**From:** [William Hodgkinson](#)  
**To:** [Andrew Cowan](#)  
**Cc:** [Sheelagh Laguna](#); [Bianca Thornton](#); [Travis Lythall](#); [Stephen O'Connor](#); [Paul Solomon](#)  
**Subject:** SSD 9667 Kemps Creek Warehouse, Logistics and Industrial Facilities Hub  
**Date:** Friday, 23 August 2019 4:15:00 PM  
**Attachments:** [Peer Review.pdf](#)

# **Mamre South Precinct Peer Review of the Overland Flow Report Stage 1 (Rev A)**

**Project: Mamre South Precinct, Mamre Road, Kemps Creek**  
**Peer Review of the Overland Flow Report Stage 1 (Rev A)**

Figure 2 Site Opportunities and Constraints Map Concerning the Subject Site and Surrounding Area (Source: Nettleton Tribe, 2018)

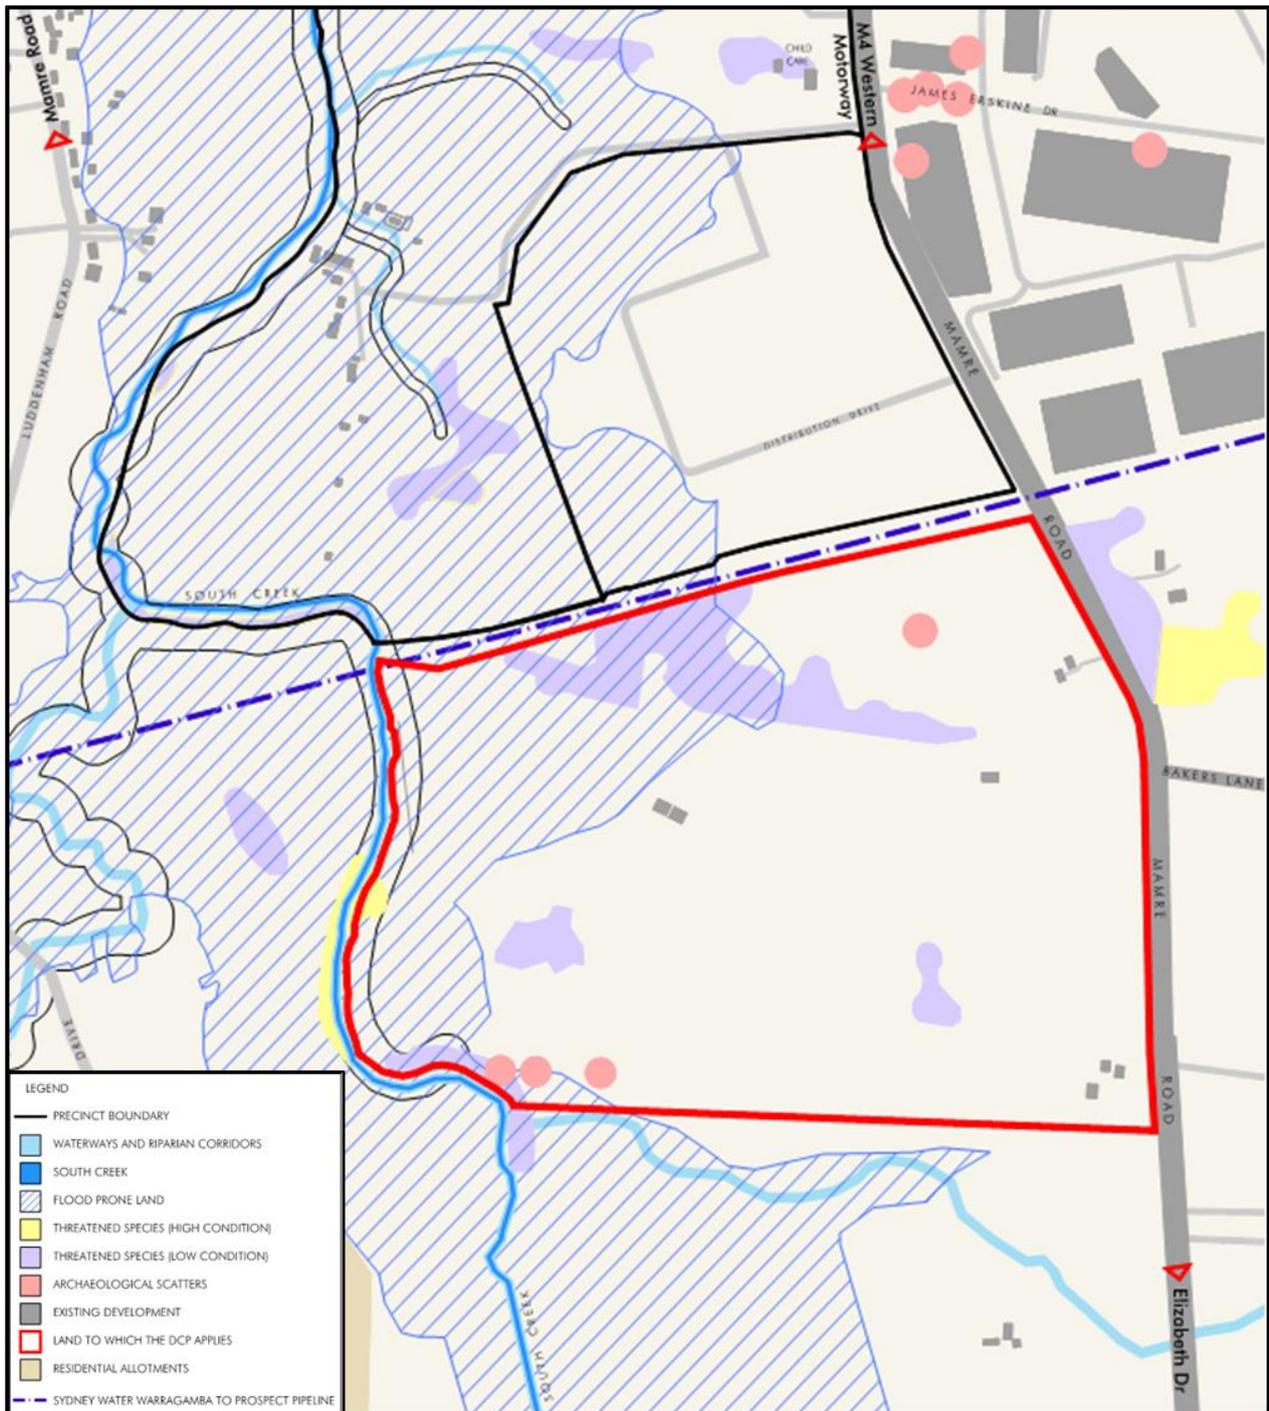
Please find attached the peer review of the Overland Flow Report, undertaken by an independent expert. It is requested that the RtS report includes a response to each of the matters raised within Section 5 – Conclusions and Recommendations.
